Application No: R/156/20/PL
Site Address: 31 Albert Road Rustington BN16 3JT
Description of works: Extension and alteration of existing residential dwelling and subdivision to form 2no. two bedroom residential dwellings, together with formation of new vehicular access and entrance drive.

Thank you for your internet representation made on 21st September 2020 which has been recorded as an objection with the comments as follows:

DRAWING TITLE
PROPOSED FLOOR PLANS & ROOF PLAN

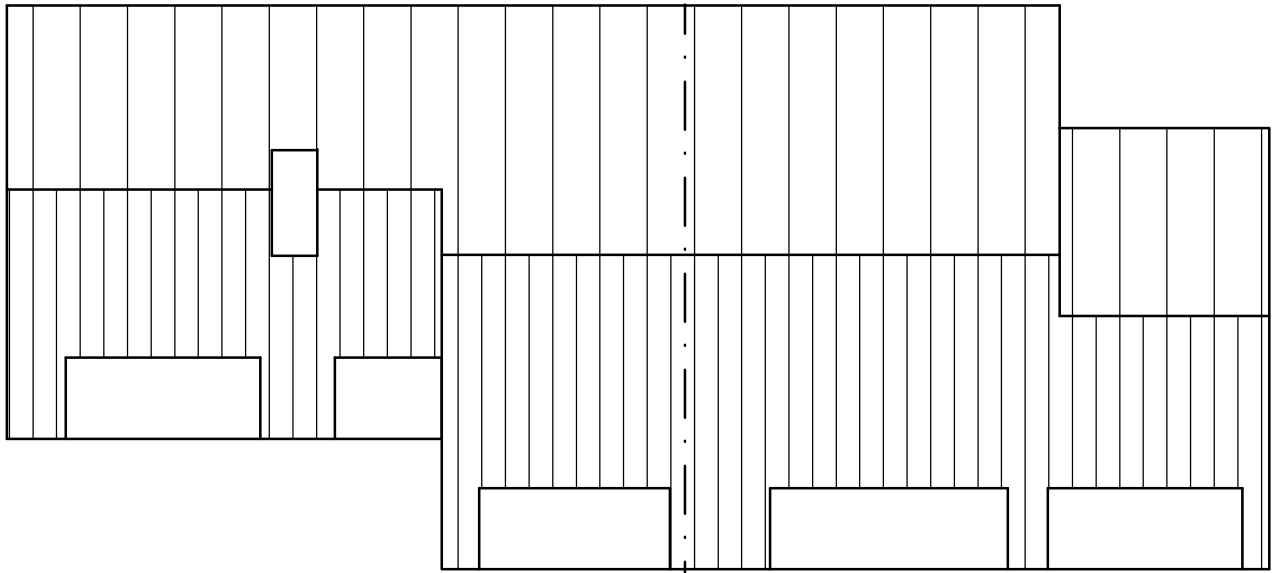
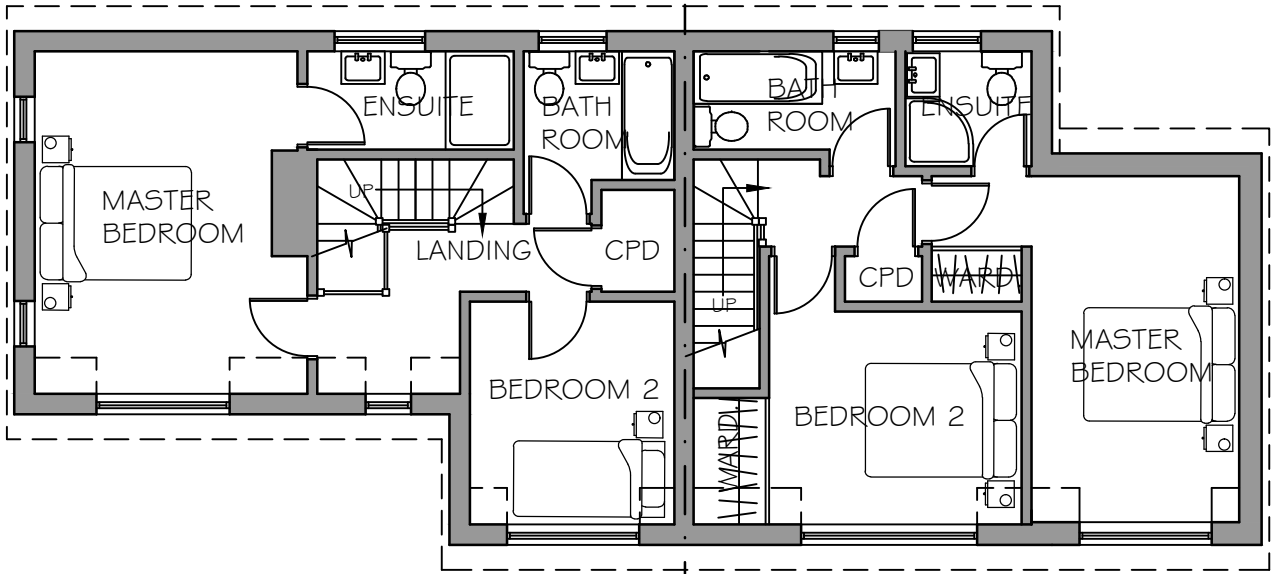
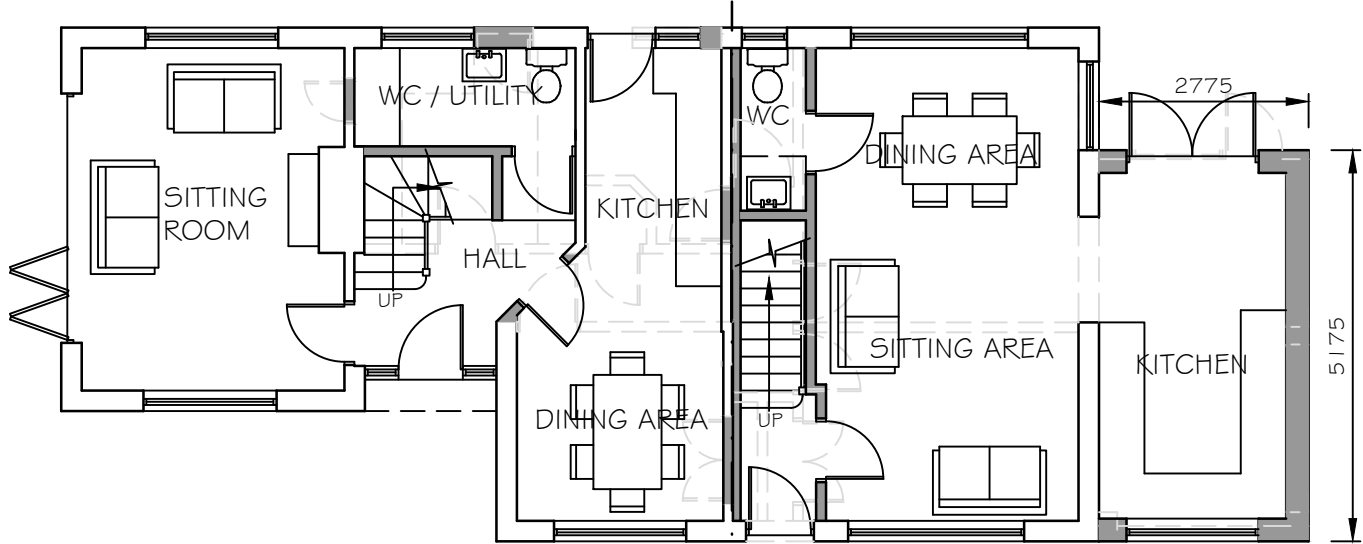
We live at 23 Mill Lane, which is directly adjacent to 31 Albert Road. The development of 31 Albert Road would have a significant impact on our residential amenities. The rooflights providing essential daylight to our new kitchen/dining area, utility room and downstairs cloakroom (see planning application R/84/20/HH approved on 21 July 2020) would be completely overshadowed by the new development.

Finally, the plot size is, we believe, too small to adequately provide for two 2-bedroomed houses with related amenities and will result in an overbearing development when considered in context with neighbouring properties.

DRAWING TITLE
PROPOSED ELEVATIONS

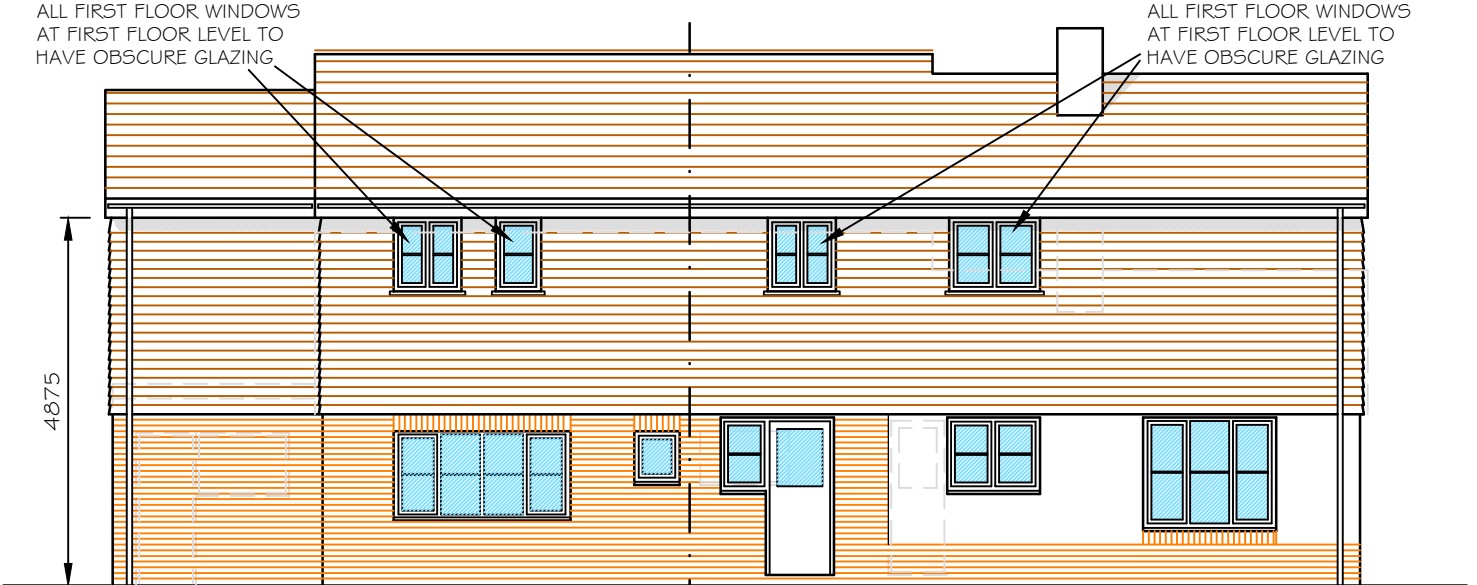
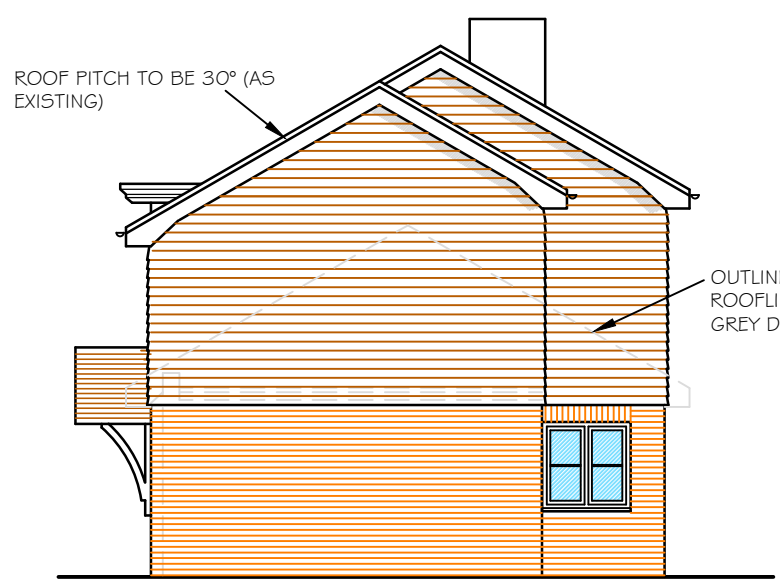
Our garden at the rear will be overlooked by the new development and even with the provision of obscured windows on the 1st floor of these houses, when they are left open (in the Summer months for example) the occupants would be able to look directly in to our garden and through the rooflights directly in to our property.
